October 29, 2018

Kari Parsons  
El Paso County Planning and Community Development

This letter responds to your MDT Letter dated 9/6/18. Our responses are provided in red below.

**EL PASO COUNTY PLANNING AND COMMUNITY DEVELOPMENT DEPARTMENT**

STERLING RANCH SKETCH PLAN AMENDMENT

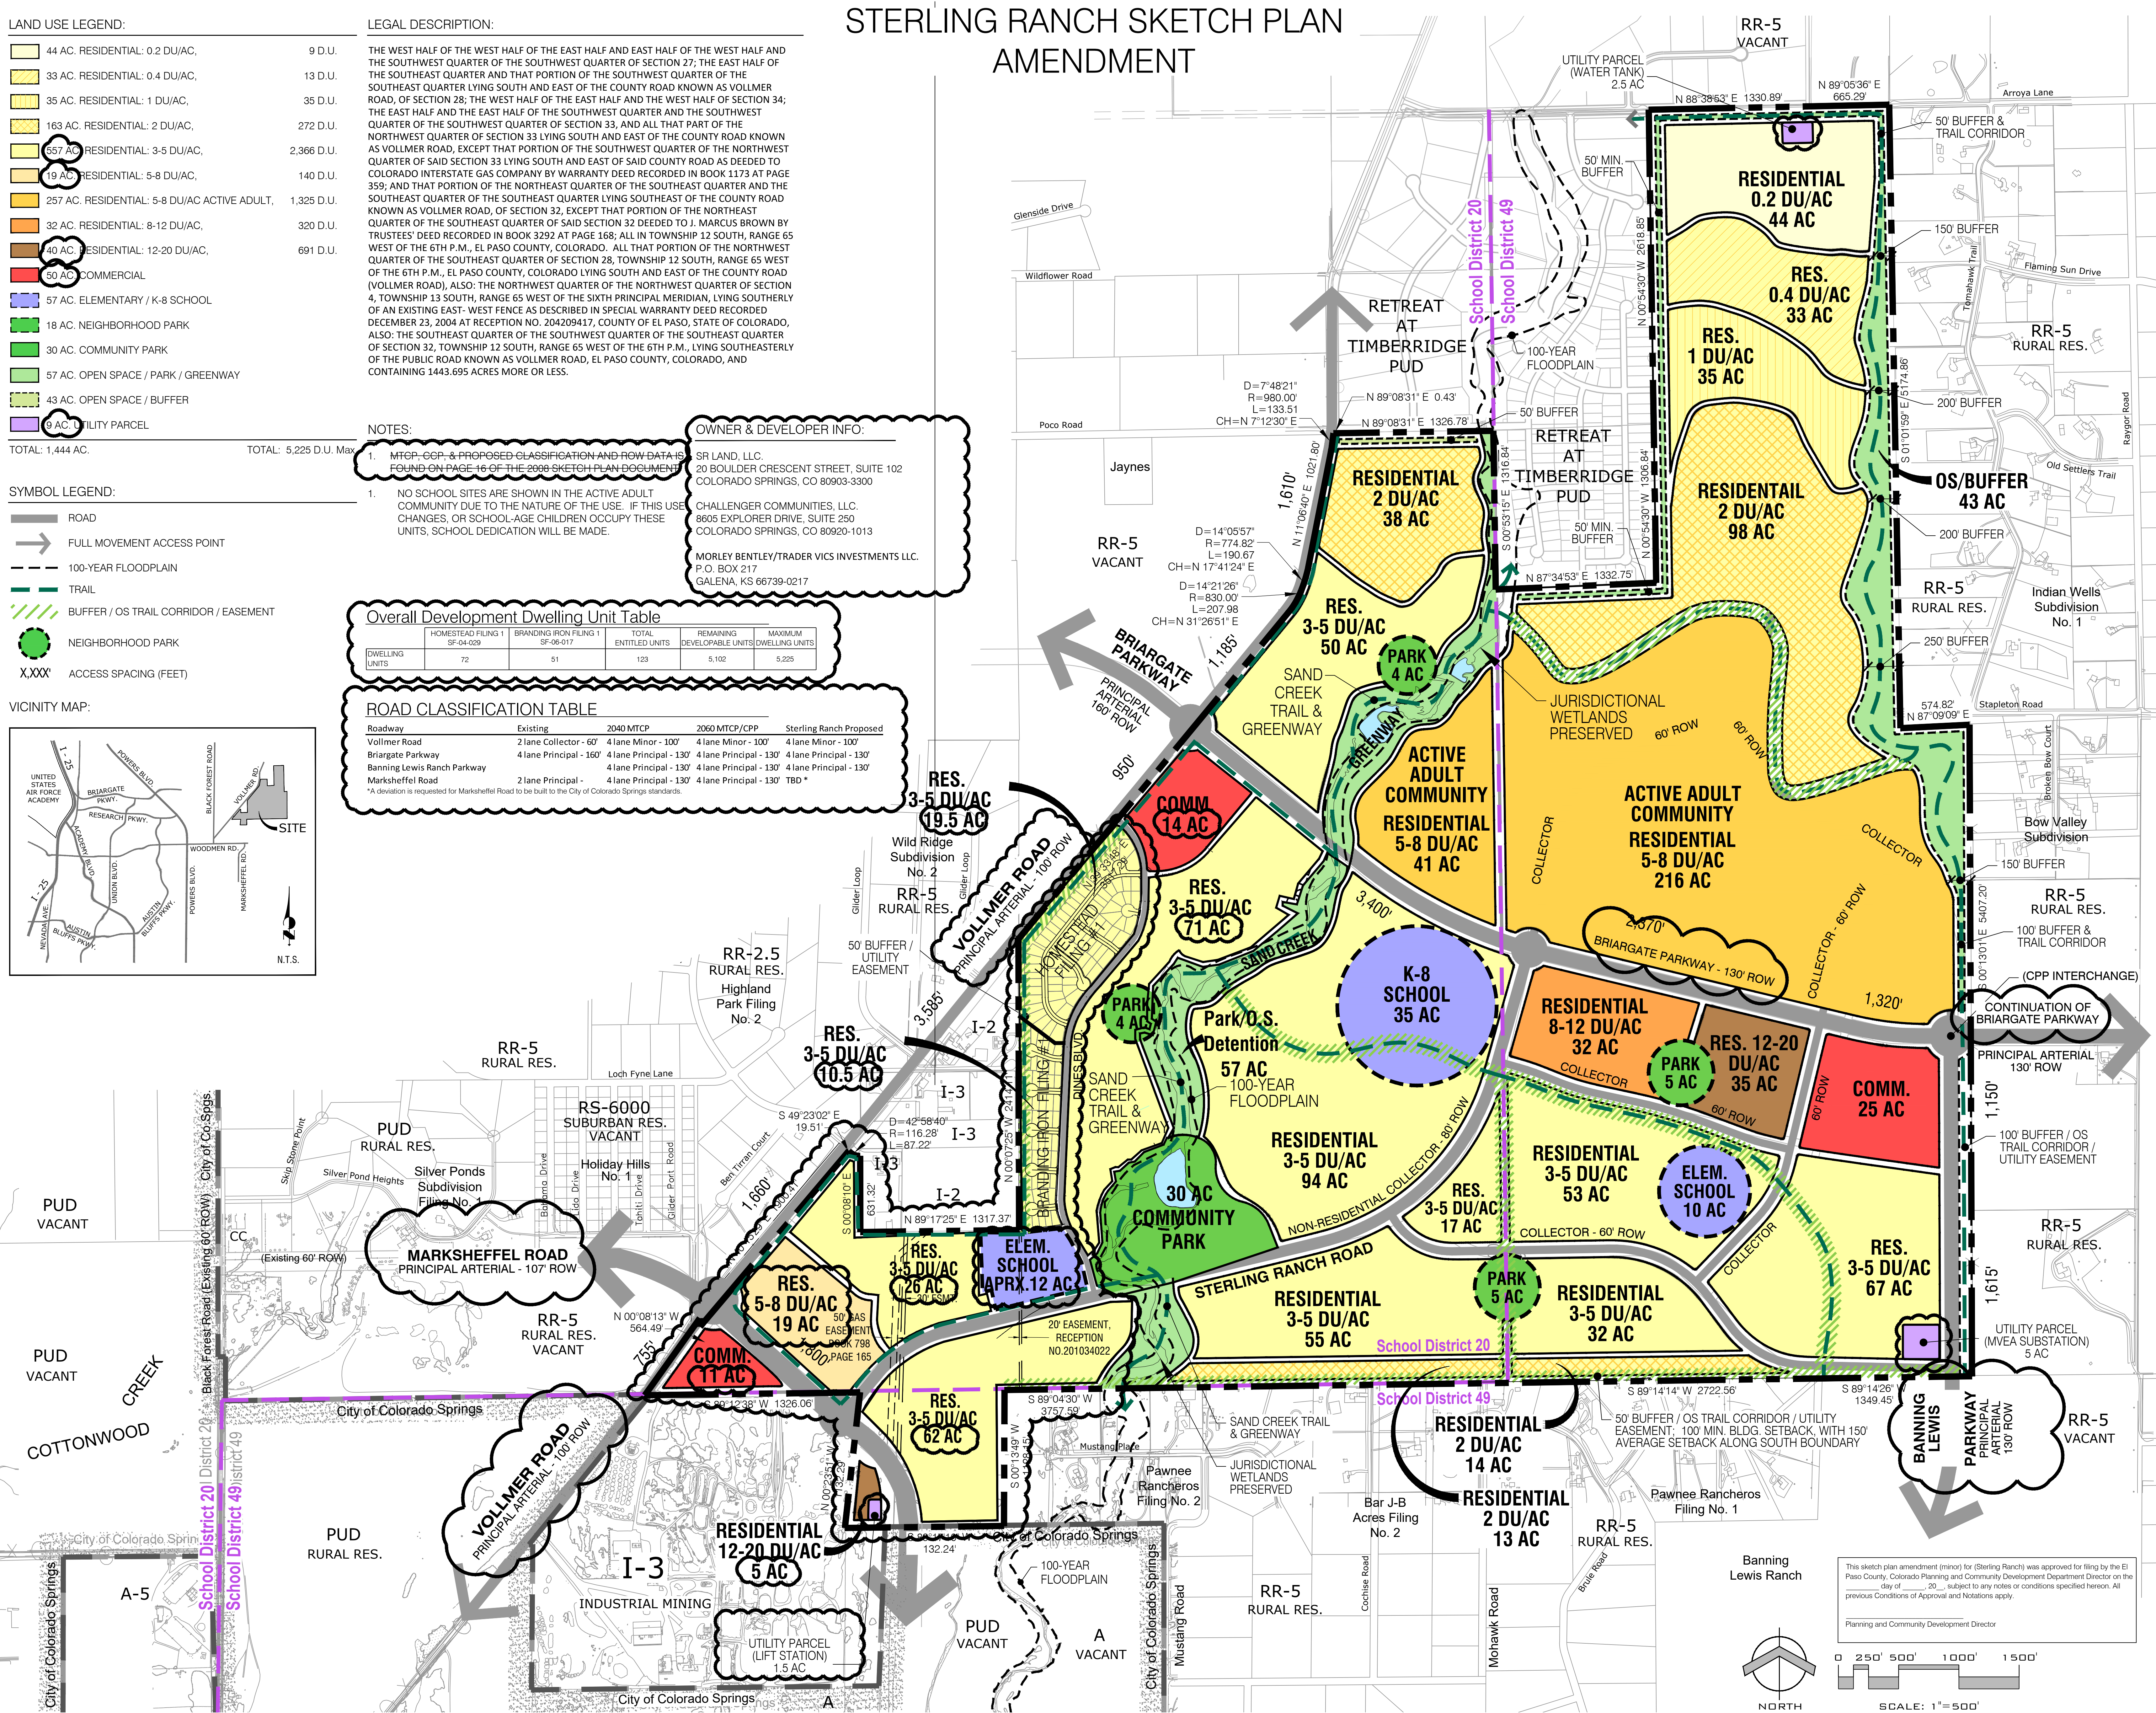
2. See uploaded redlines in EDARP.  
– Responses to redlines have been uploaded.
3. The sketch plan amendment has outdated notes and references on it. Please quality control check the document (and associated submittal documents) so that it is relevant to today's plans to include changes over the last decade. Please cloud the areas you're amending on the drawing. The plan and application will be reviewed upon submitted changes.  
– Notes have been updated and cloud lines have been added to identify amended areas.

- In coordination with MVEA a substation location has been identified and added to the Sketch Plan. Utility easements will be identified on subsequent plans.
